Phone: 0300 123 6780
Email: Kathryn.Walsh@lancashire.gov.uk
Your ref: 3/2024/0618
Our ref: 3/2024/0618/HDC/KW
Date: 13 November 2024

Location: Bolton Fold Farm Alston Lane Longridge PR3 3BN
Proposal: Proposed change of use of a building and yard from agricultural to industrial storage and hardstanding. Replacement of existing walls and roof with new cladding and new roller shutter doors.
Grid Ref: 360295 435306

Lancashire County Council acting as the Local Highway Authority (LHA) does not consider that the application as submitted fully assesses the highway impact of the proposed development and further information is required as set out in this response.

**Drawing Title**  
 PROPOSED SITE PLAN

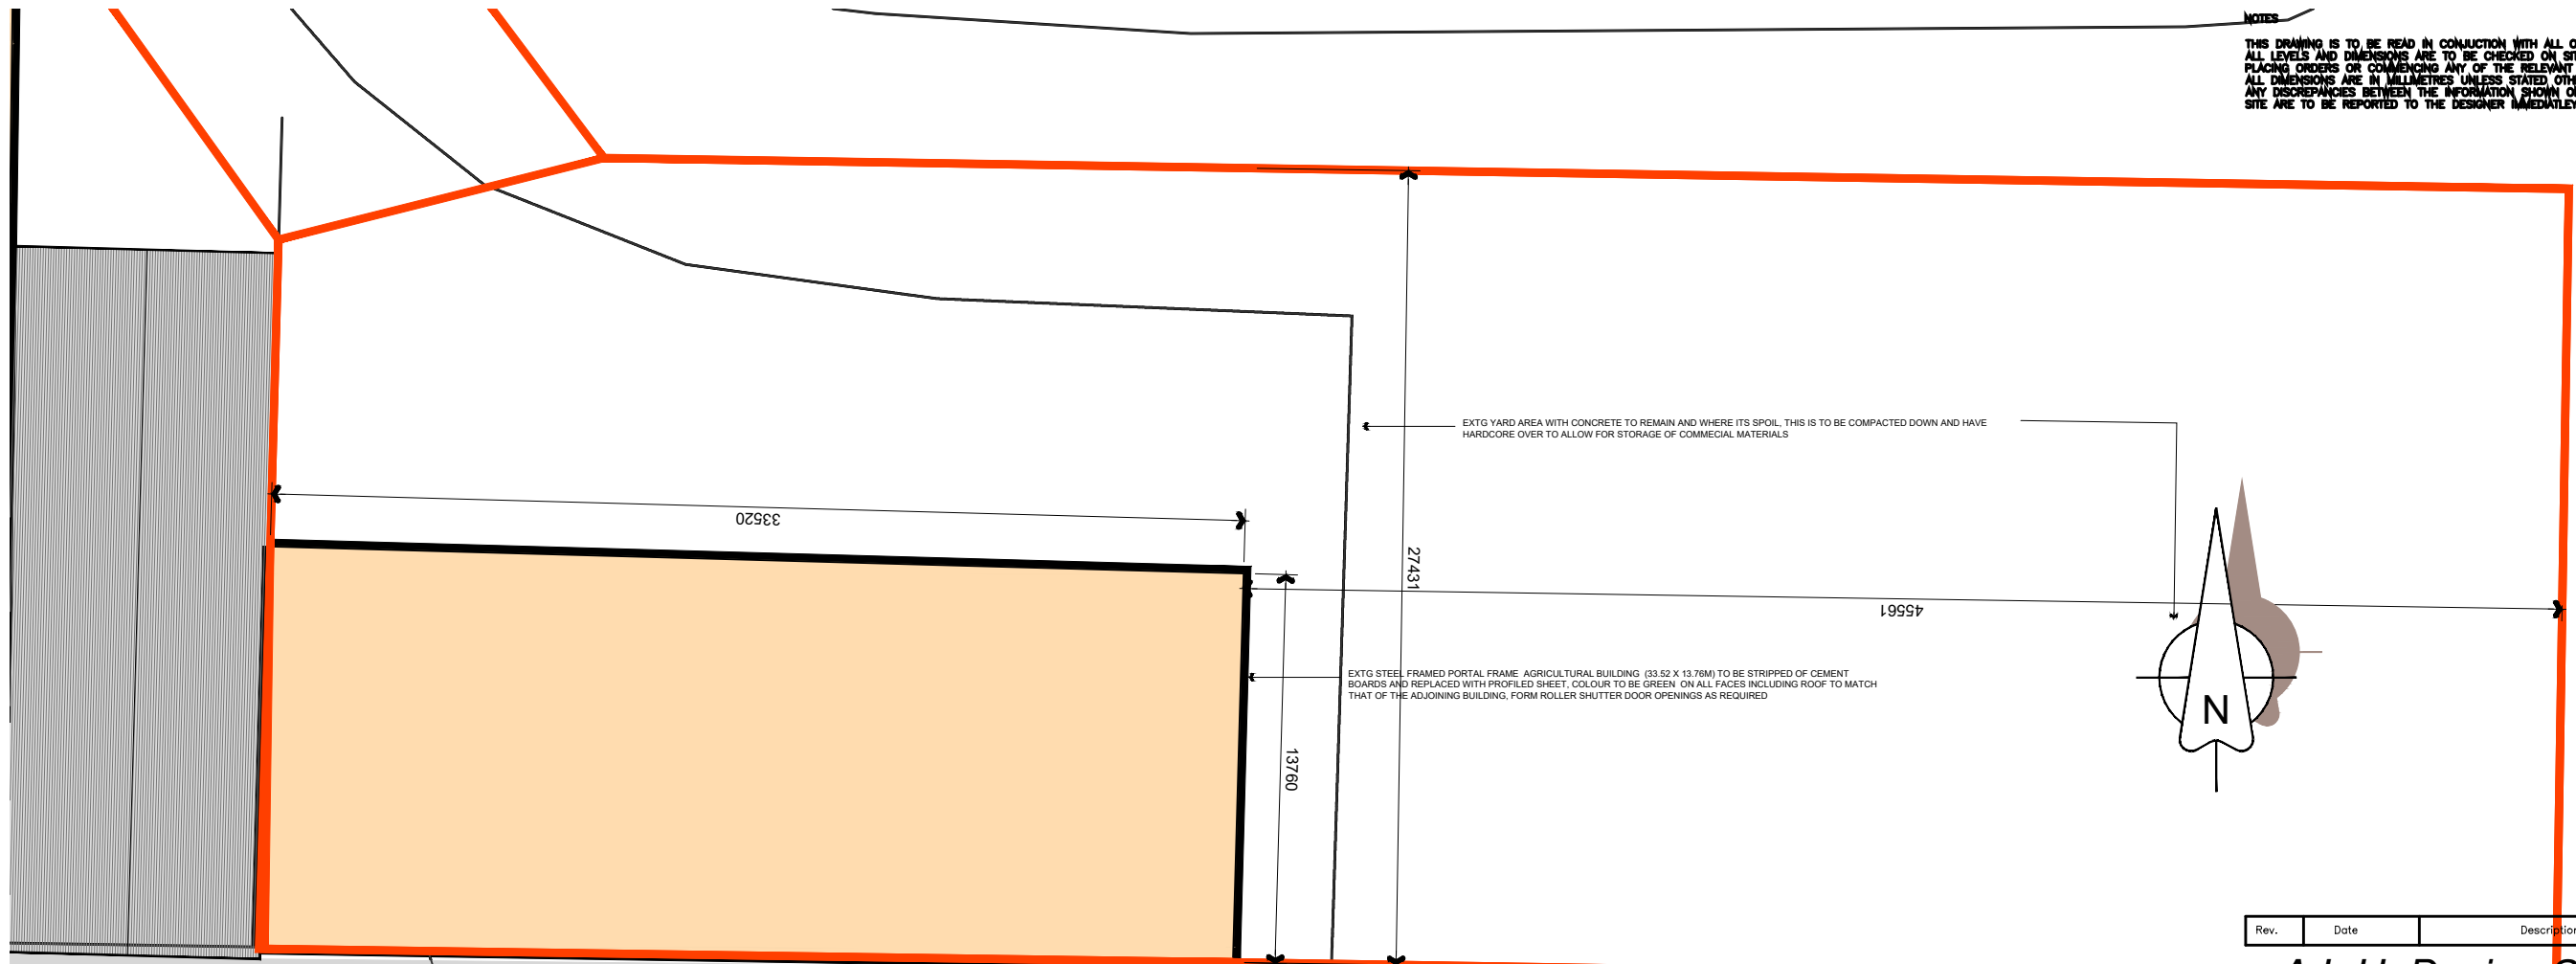
The LHA has reviewed the proposed site plan drawing number 0 8 and drawing number 0 9 and whilst the applicant has provided information regarding parking provisions within the application form these have not been included within the plans. We require a detailed parking plan alongside a swept path analysis showing the largest vehicle accessing the development turning within the site to enable them to leave in a forward gear.

The applicant should also provide confirmation on the use class of the proposal so that the car parking provisions can be calculated following the guidance within the Joint Lancashire Structure Plan.
